**Mountain Splendor Services, Inc., PPR-18-017**

Please accept the following comments from El Paso County Public Health for the project referenced above:

1 OVERALL SITE PLAN

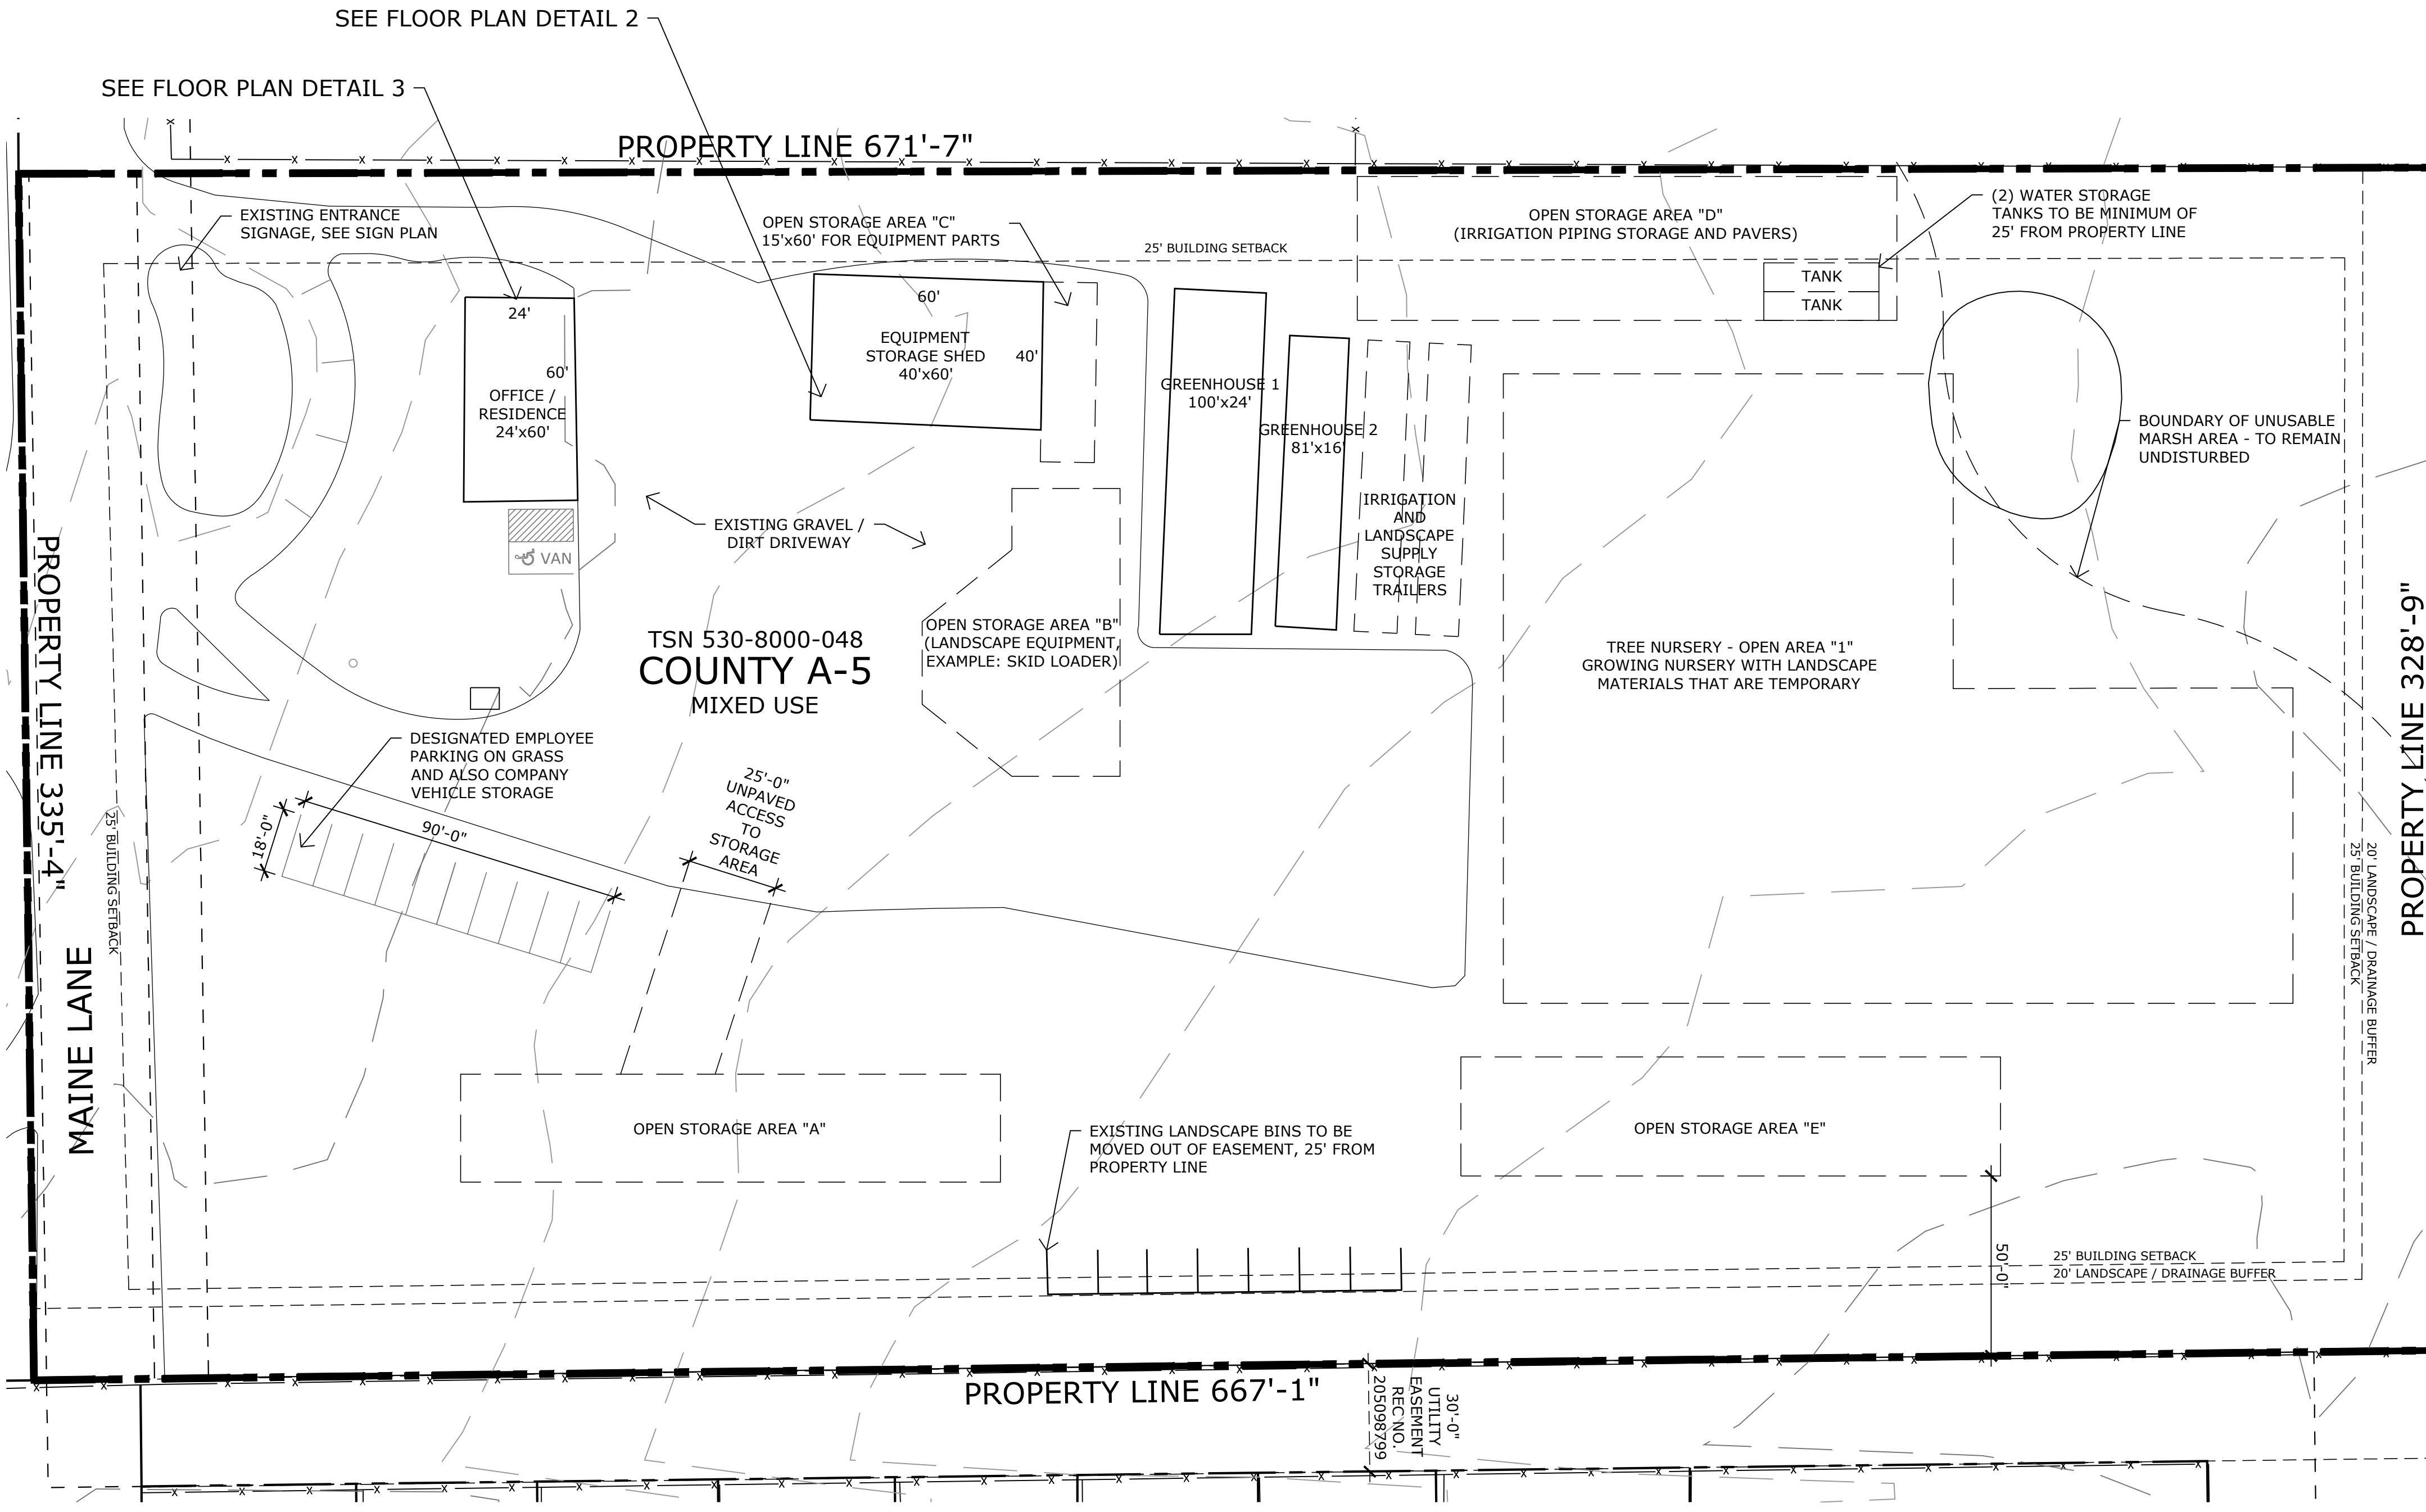
- The permitted and approved onsite wastewater treatment system (OWTS) was installed in 1988 and sized for a 3 bedroom house. The soil treatment area (STA) is located south and east of the house/office, and is not identified on the site plan. A map of the OWTS components is available on the El Paso County Assessor's Office website: <http://www.land.elpasoco.com/default.aspx>
- The existing primary STA must be located, and traffic control measures must be taken to protect it from compaction by vehicular traffic. There must be an equally sized secondary STA site identified and protected from compaction that meets the 100' setback from the existing well. This site is required in the event that the primary site were to require repair or replacement.
